From: Anita Gardner [REDACTED]
Sent: 02 June 2020 16:26
To: Planning.Responses [REDACTED]
Subject: FW: Planning Consultation on M/28/20/DOC

Engineers comments;

The level of detail supplied is currently insufficient to enable the discharge of conditions 11, 13 or 14.

Figure 1
Groundwater Level at all Boreholes

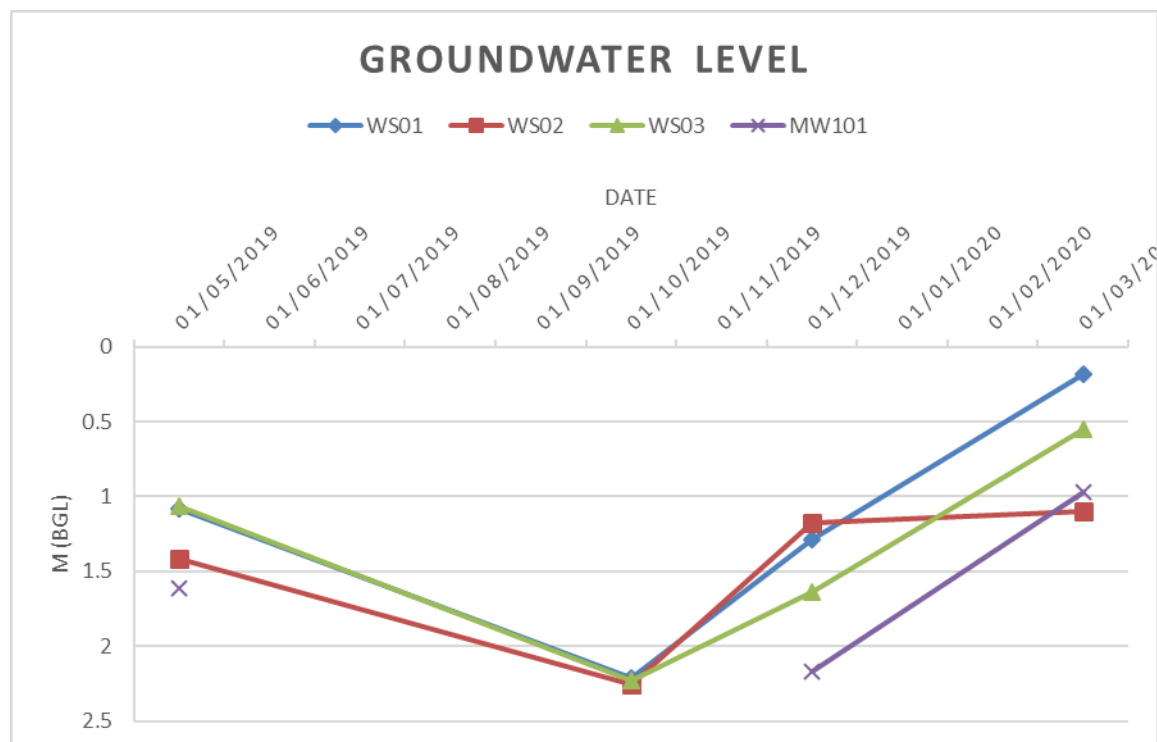
Firstly, we need to be sure that shallow infiltration is not possible, as part of an overall scheme. Please provide a plan showing all the groundwater monitoring point locations and the monitoring results for all, not just WS02. Achieving 1m freeboard between the base of structures and the peak recorded groundwater level is not a requirement in this particular area, so long as the base is above the peak recorded level. This information will dictate as to whether shallow winter infiltration testing will be required.

Figure 4
Route 1 Plan and Section AA'

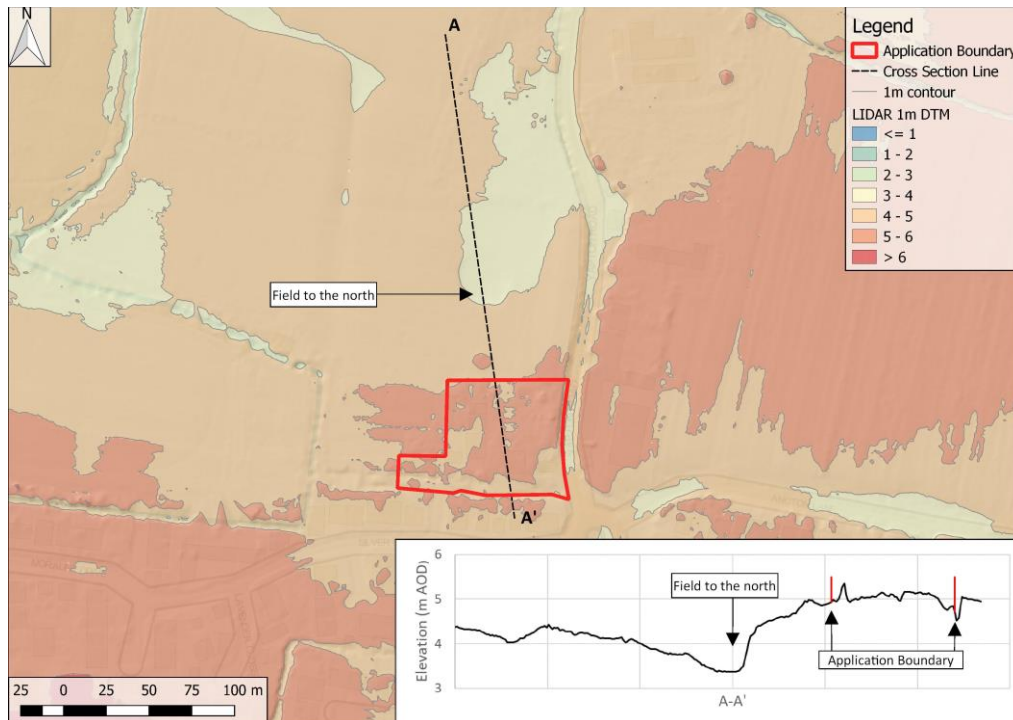
The applicant should also provide topographical evidence to show that no overland/exceedance run off flows from the field to the north will have any detrimental effect on the development/suds.

Site: YAPTON POULTRY FARM
Project: MIDDLETON RESIDENTIAL
Date: 01/07/2020
Drawing: SITE VISIT DISCUSSION
APPENDIX 02

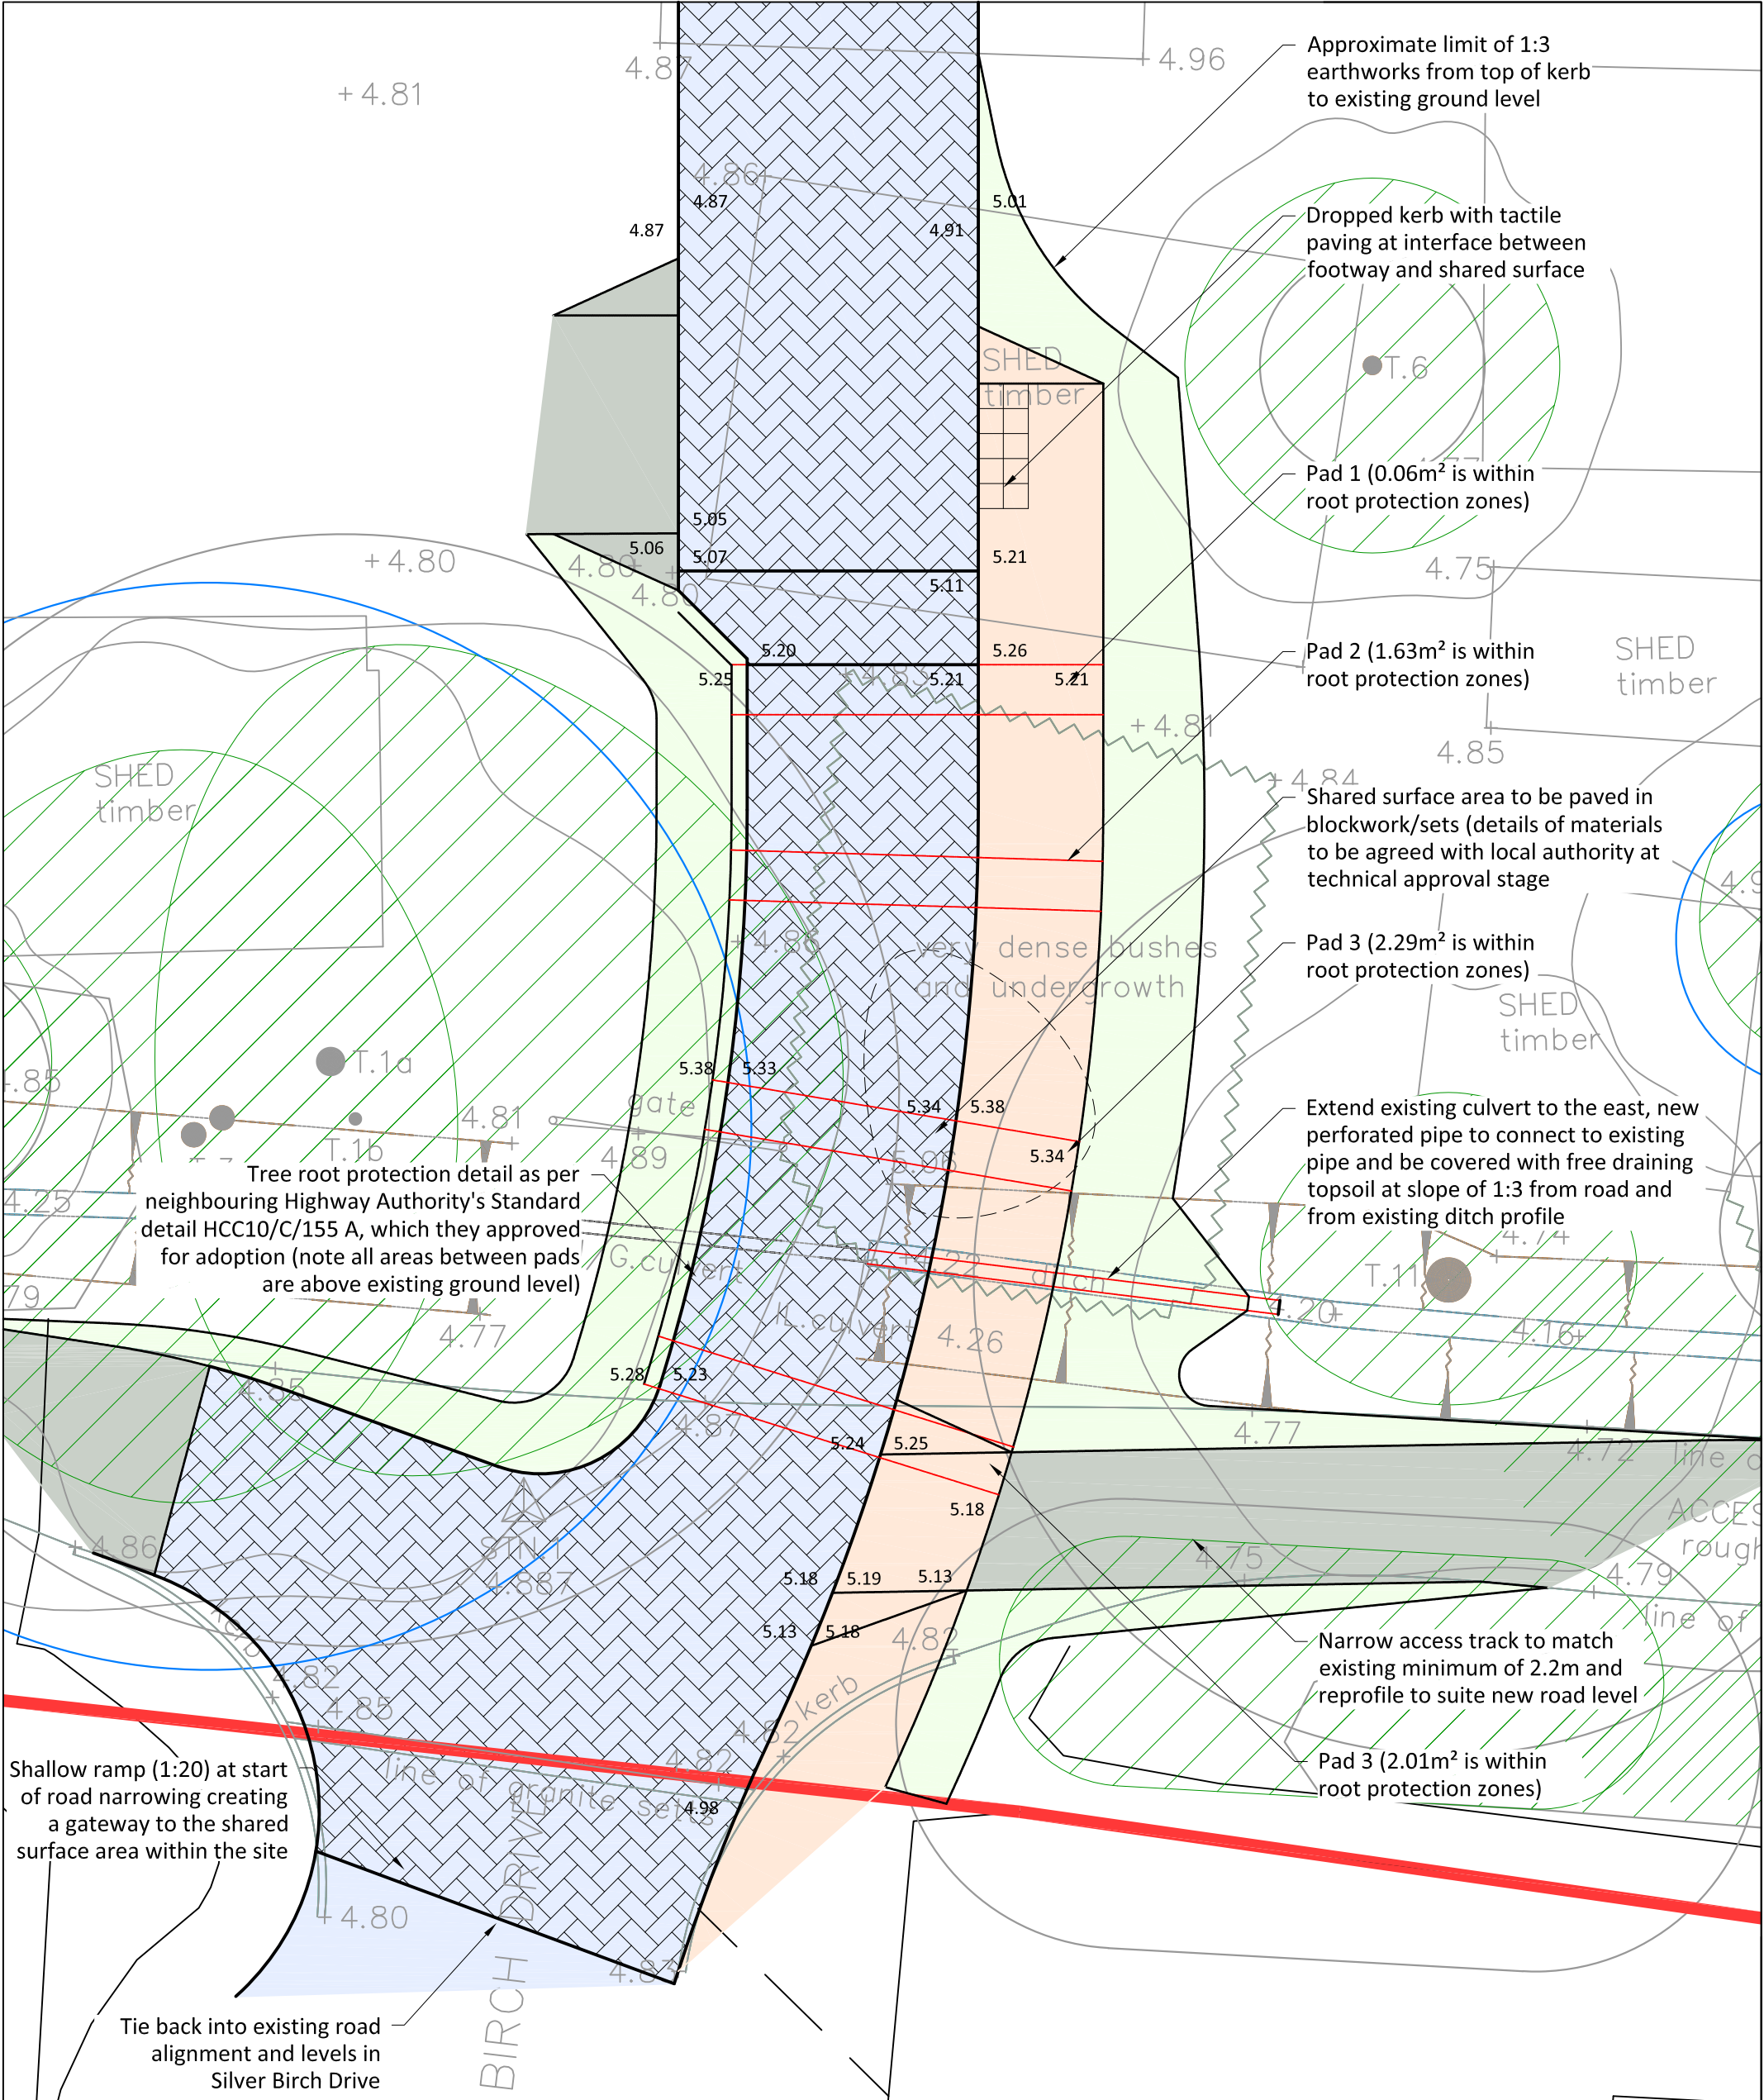
Regarding the ditches on the southern boundary, it is very likely that these will need improvements and I suggest a meeting takes place on site to look at these. Land Drainage Consent will be required for any alterations to them, including culverting and any discharge structures. This will all need to be fully detailed on the drawings.
